Woollahra
Municipal
Council

16 December 2010

**Scottish Hospital 74 Brown Street (aka 2 Cooper Street), Paddington
Submission to Seniors Living Project Application**

DRAWING TITLE
Sections
DRAWING No
DA 438

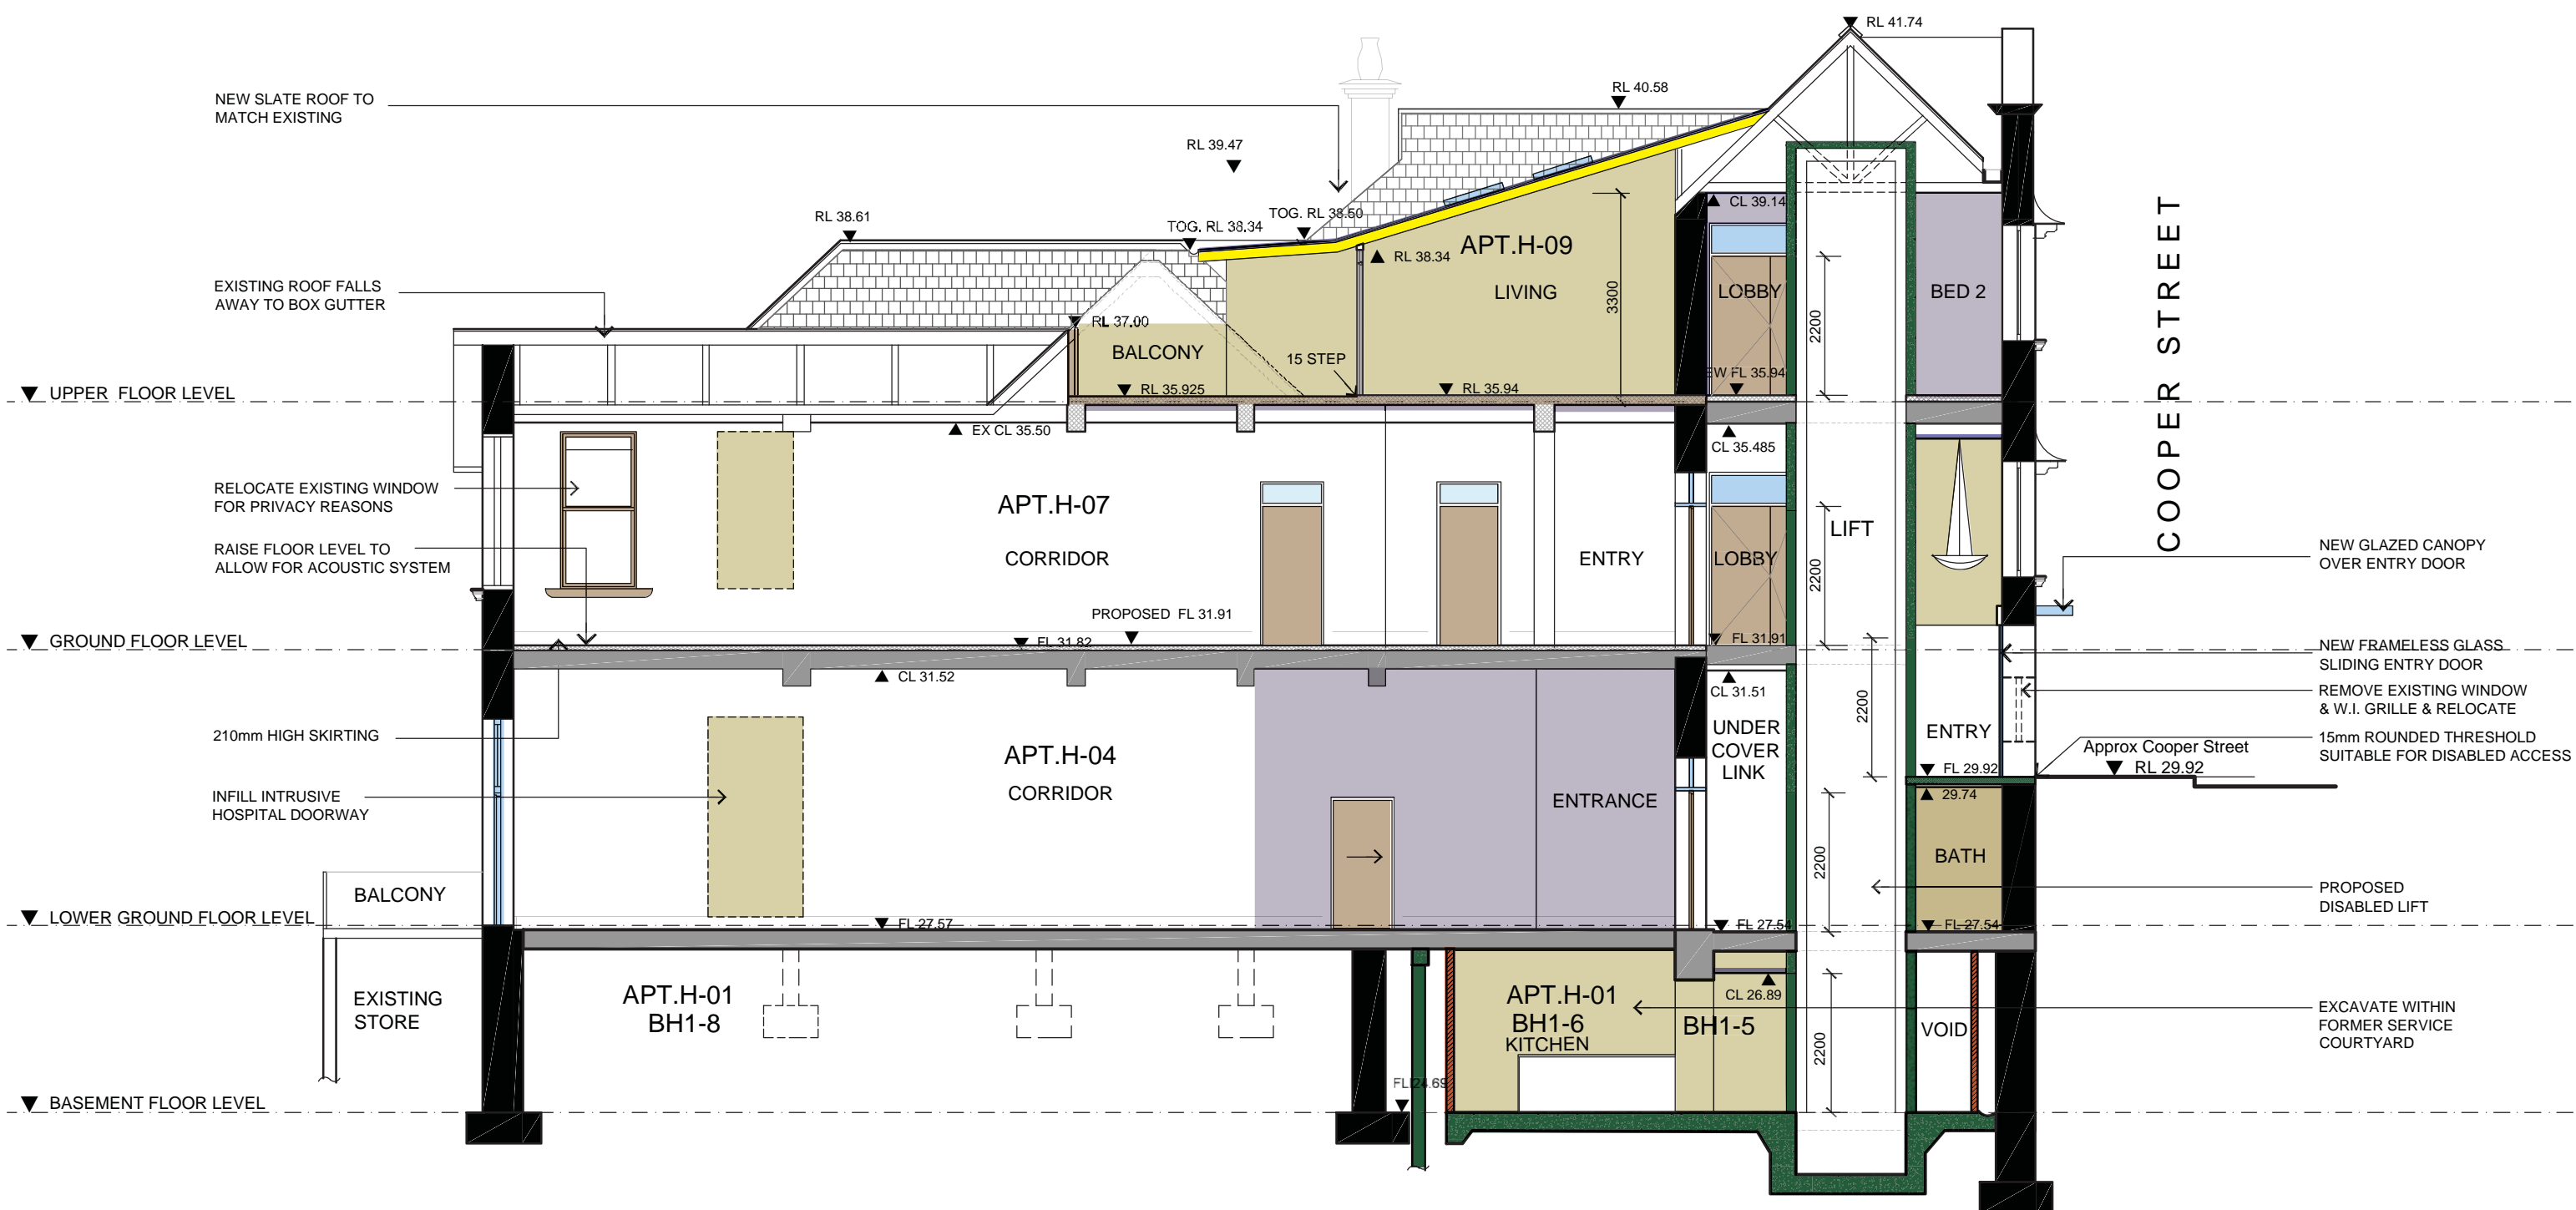
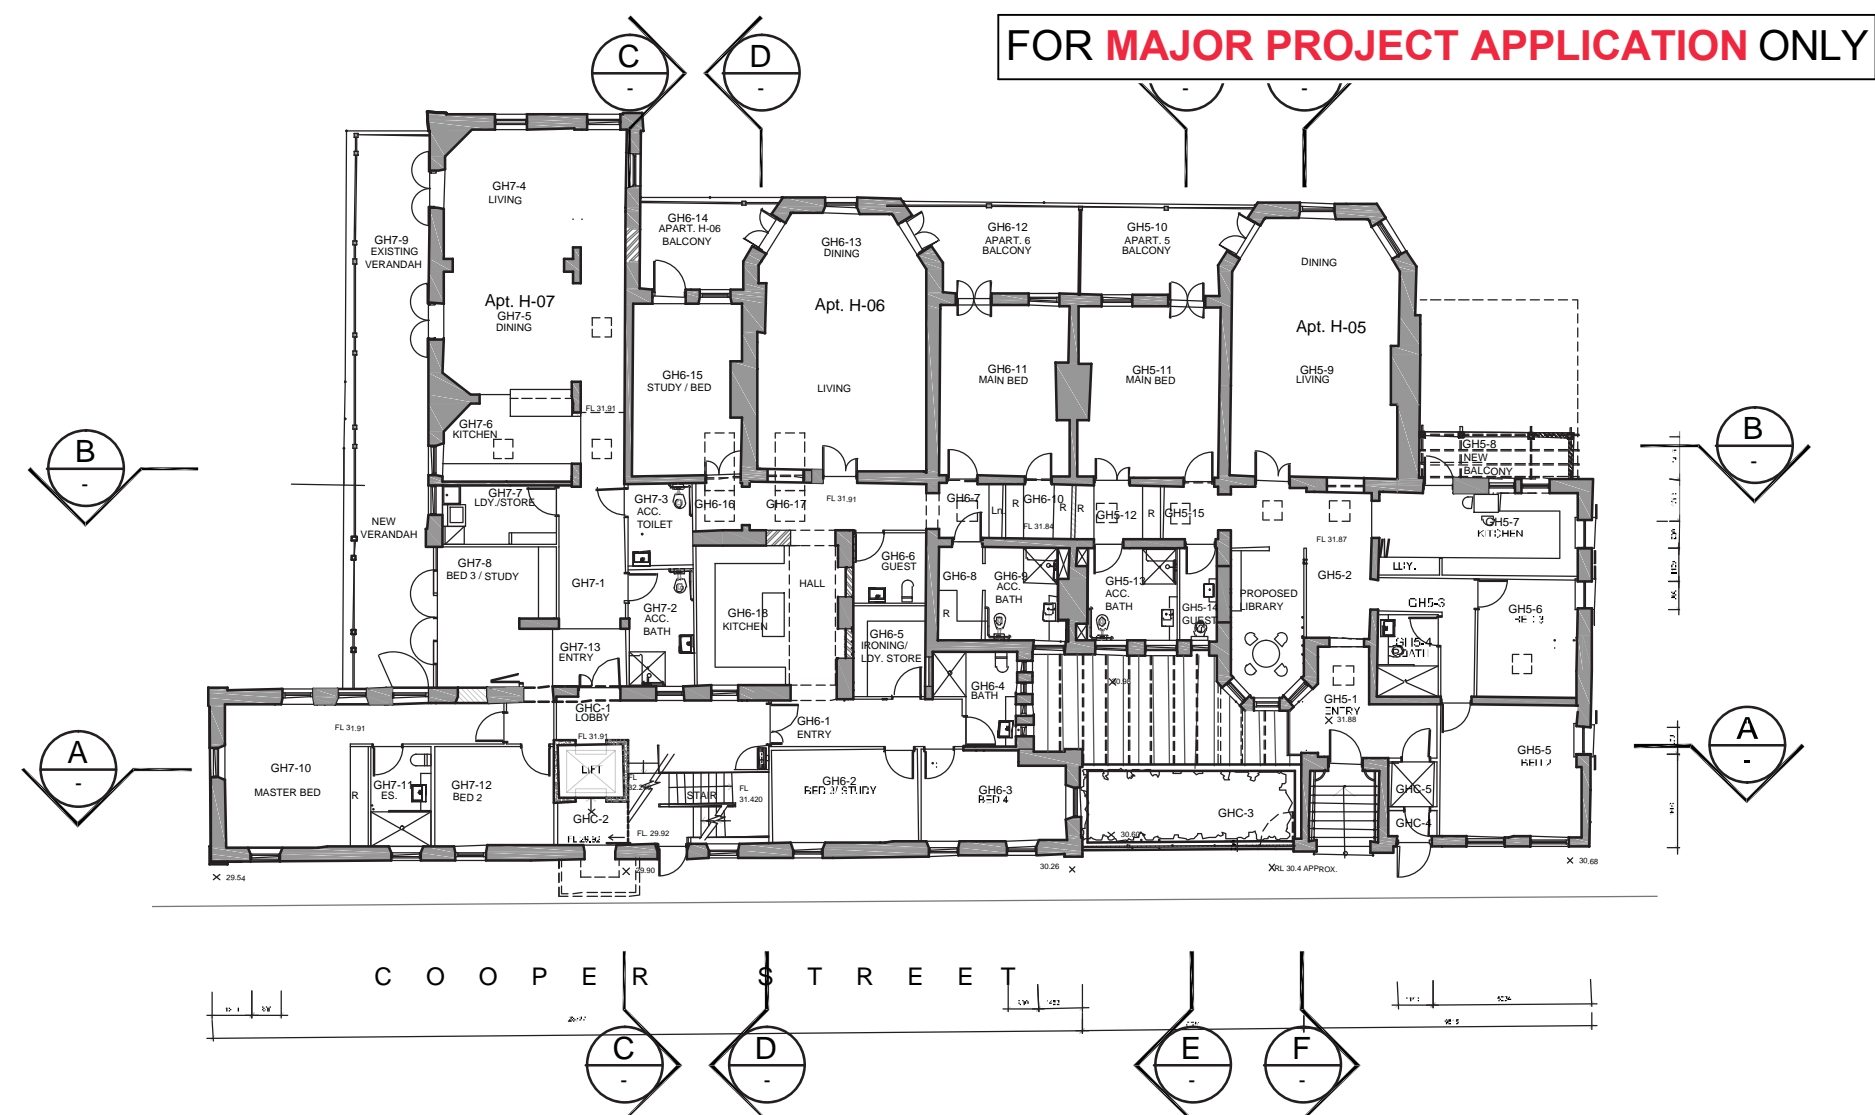
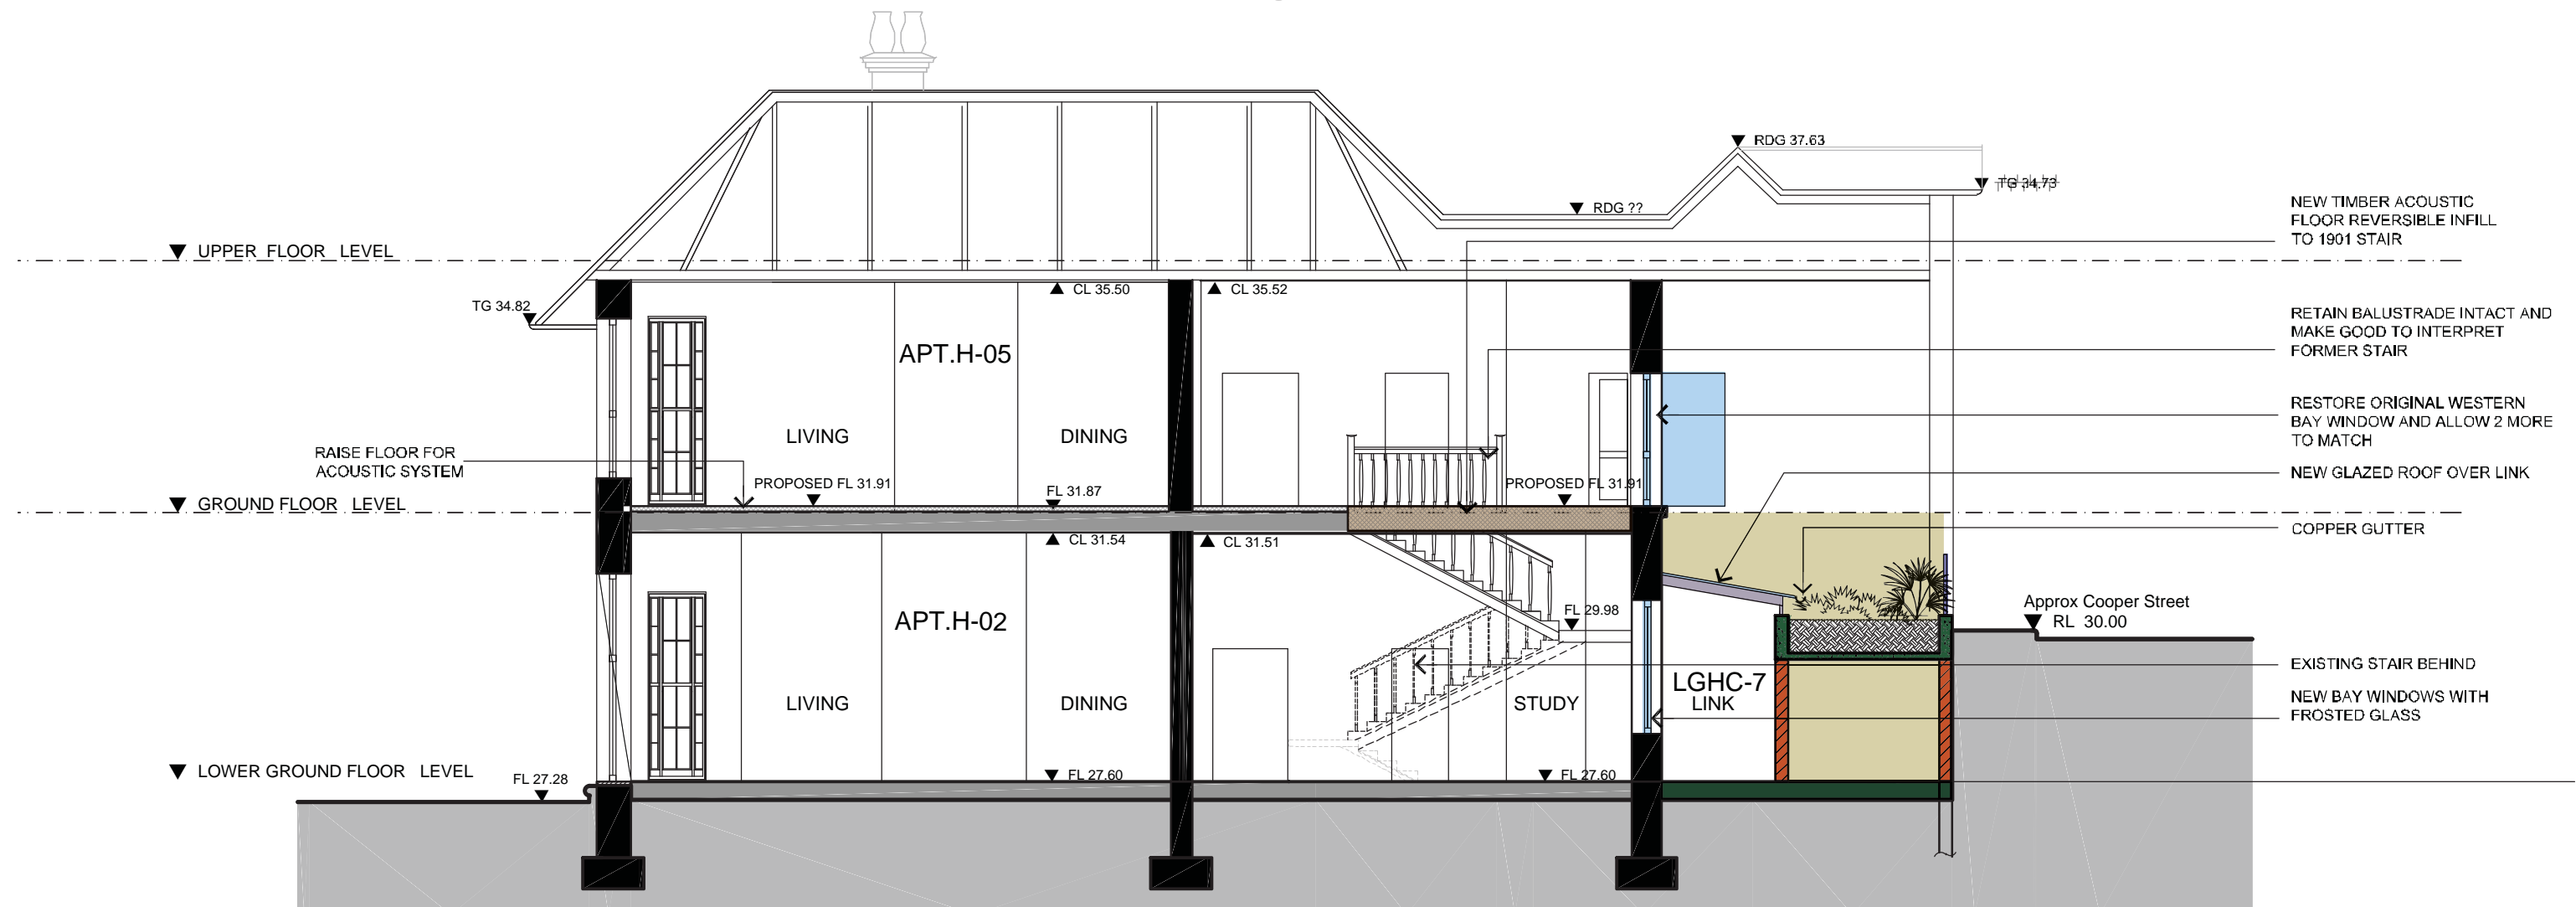
5. *The alterations to the roof level of the heritage listed Scottish Hospital building, as recognised by the NSW Heritage Inventory and the Woollahra Local Environmental Plan 1995, will unacceptably reduce that building's heritage significance.*
